Ref - Planning Application M/80/19/PL

As a resident of Silver Birch Drive for over 15 years , and living in a property potentially backing on to the proposed development, and adjacent to the planned access road I would like to strongly object to the planning application M/80/19/PL for the following reasons:-

402.06594.00008:14.TR04.RevA.dwg

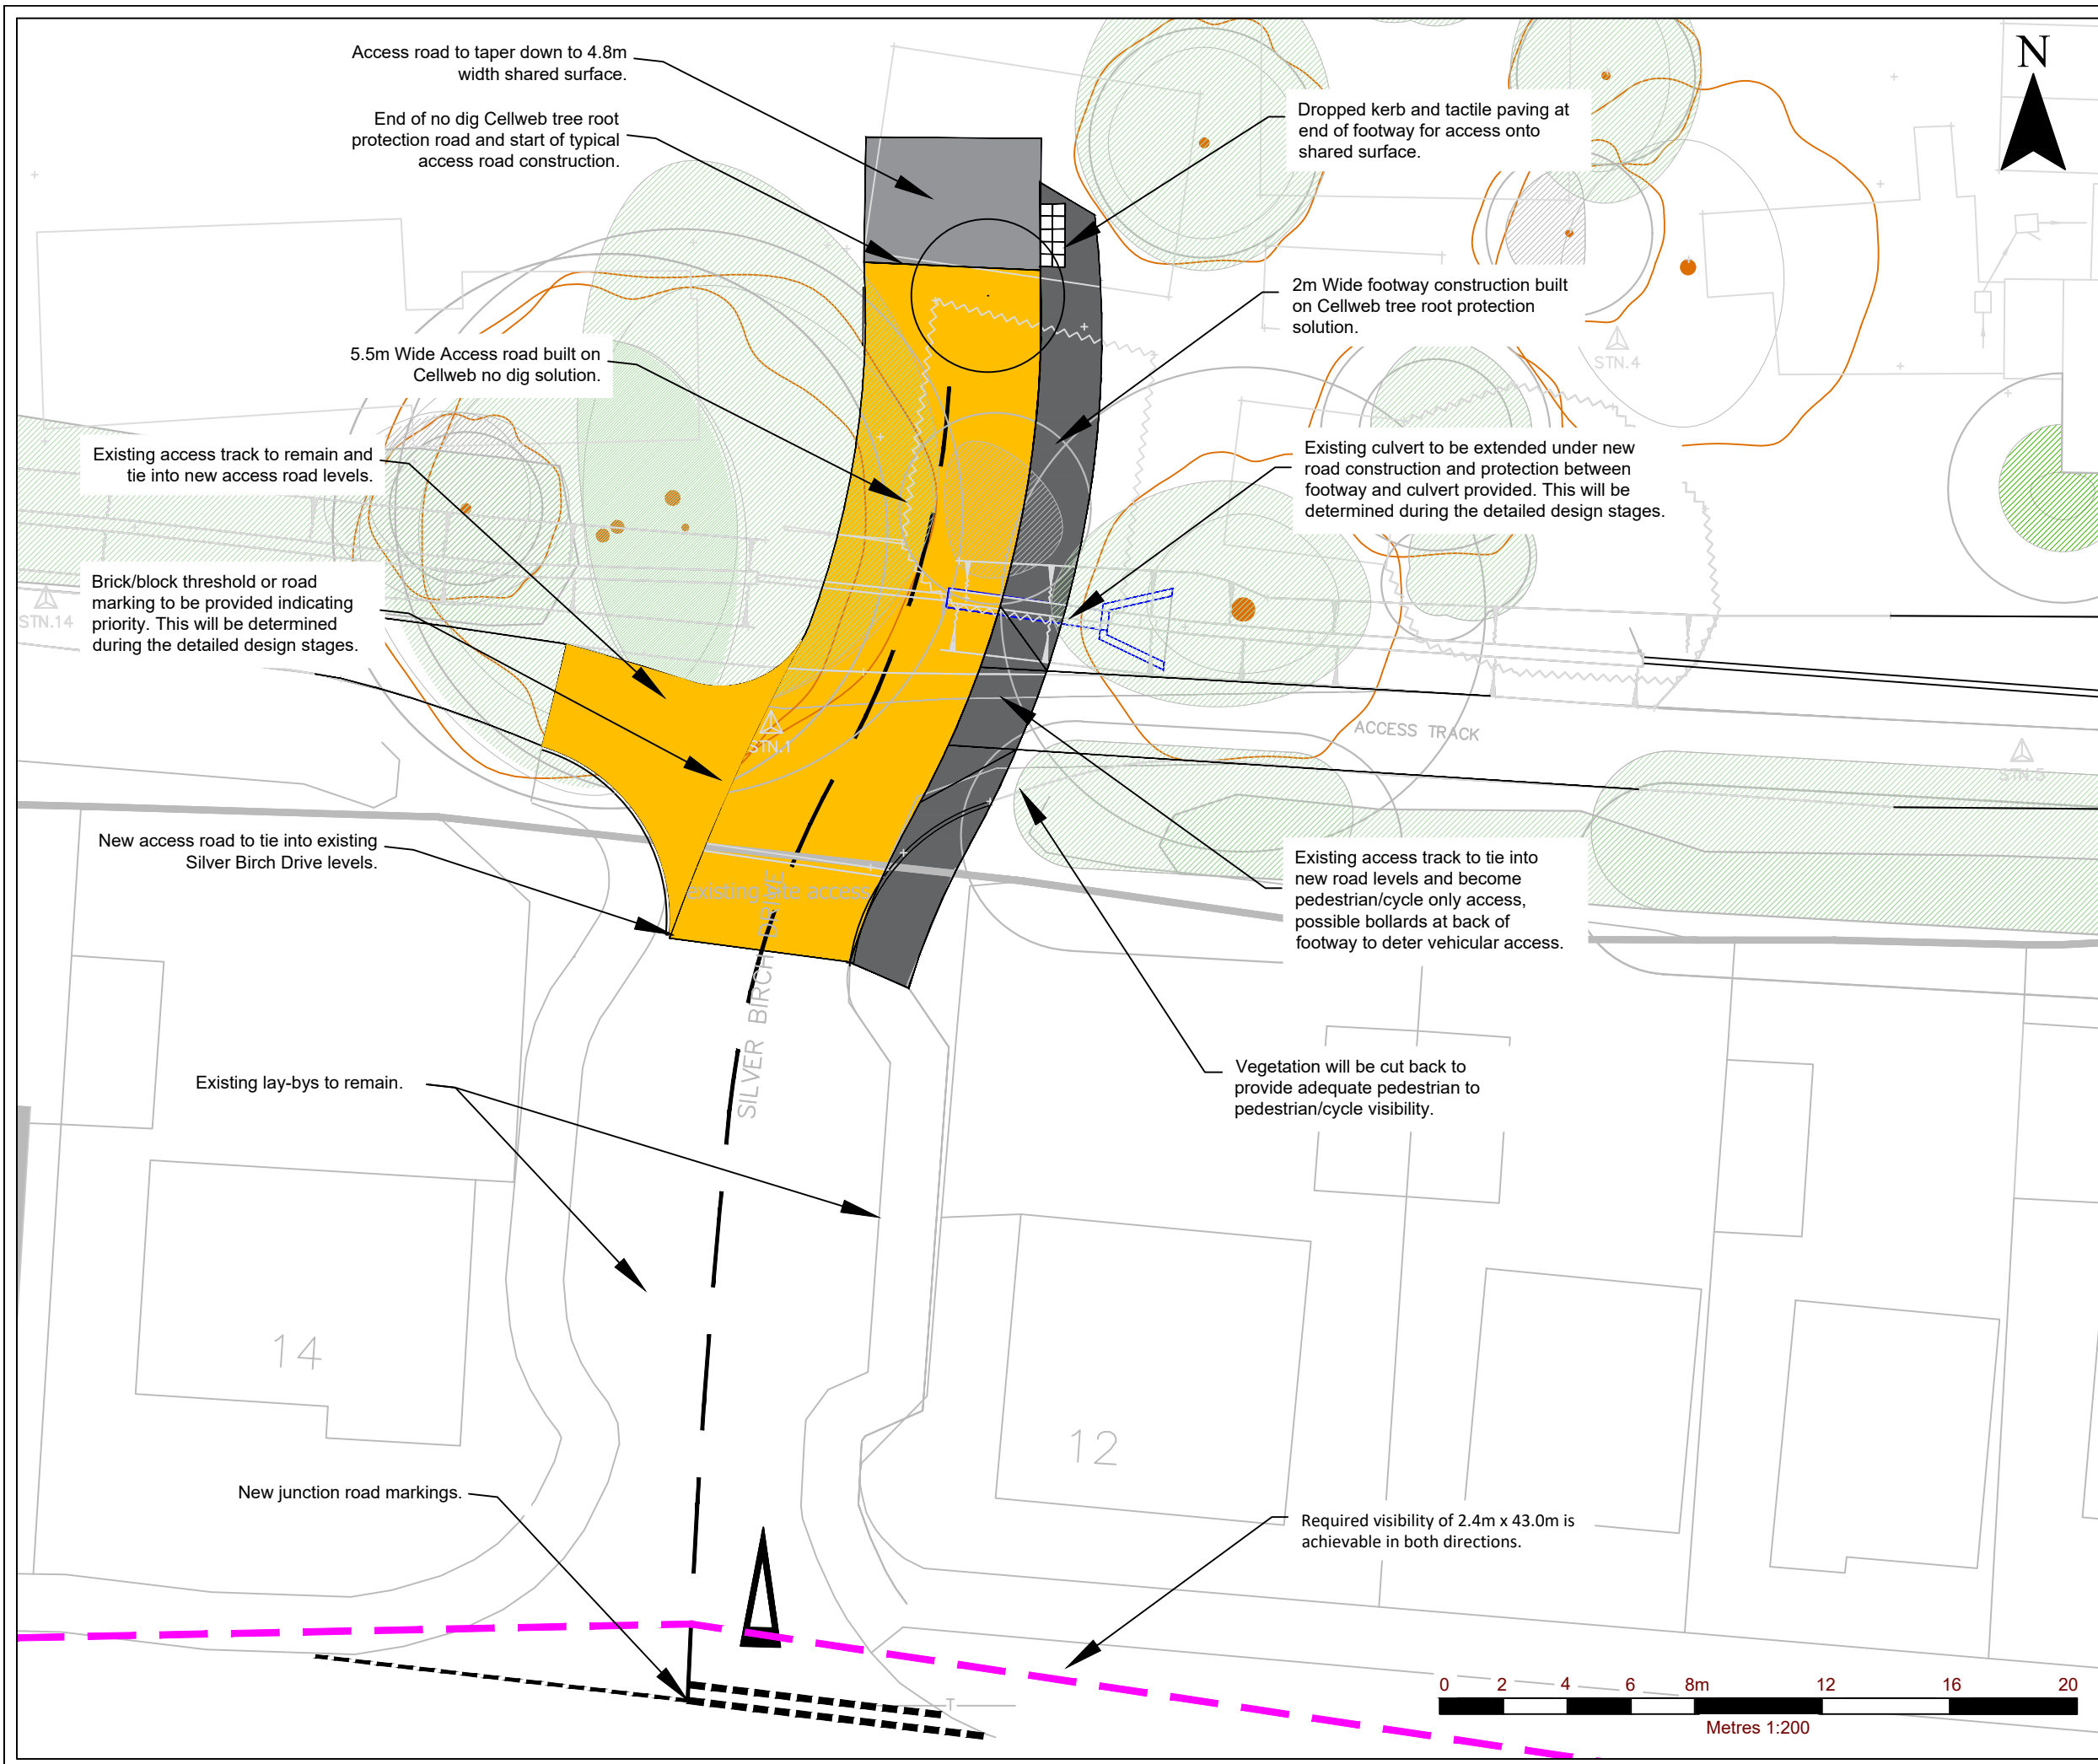
This is a commercial development operating 24/7 365 days a year. Access to this proposed development is down a very tiny spur road in the middle of a residential estate, right next to my house. Making this an access for a commercial business would be extremely dangerous. I have never seen the gate open for vehicular access, so it is not an established access route. Frontier Estates artists impression for access to this site is misleading.

Three years ago planning was agreed for thirteen houses using this very same access, when access was never viable without huge damage/destruction to the protected trees and their roots and a very well used footpath. I would like to draw your attention to the following enclosed documents -

The canopy of the trees are too low for car, van and lorry access. Huge amounts of the tree will need to be chopped causing damage & destruction.
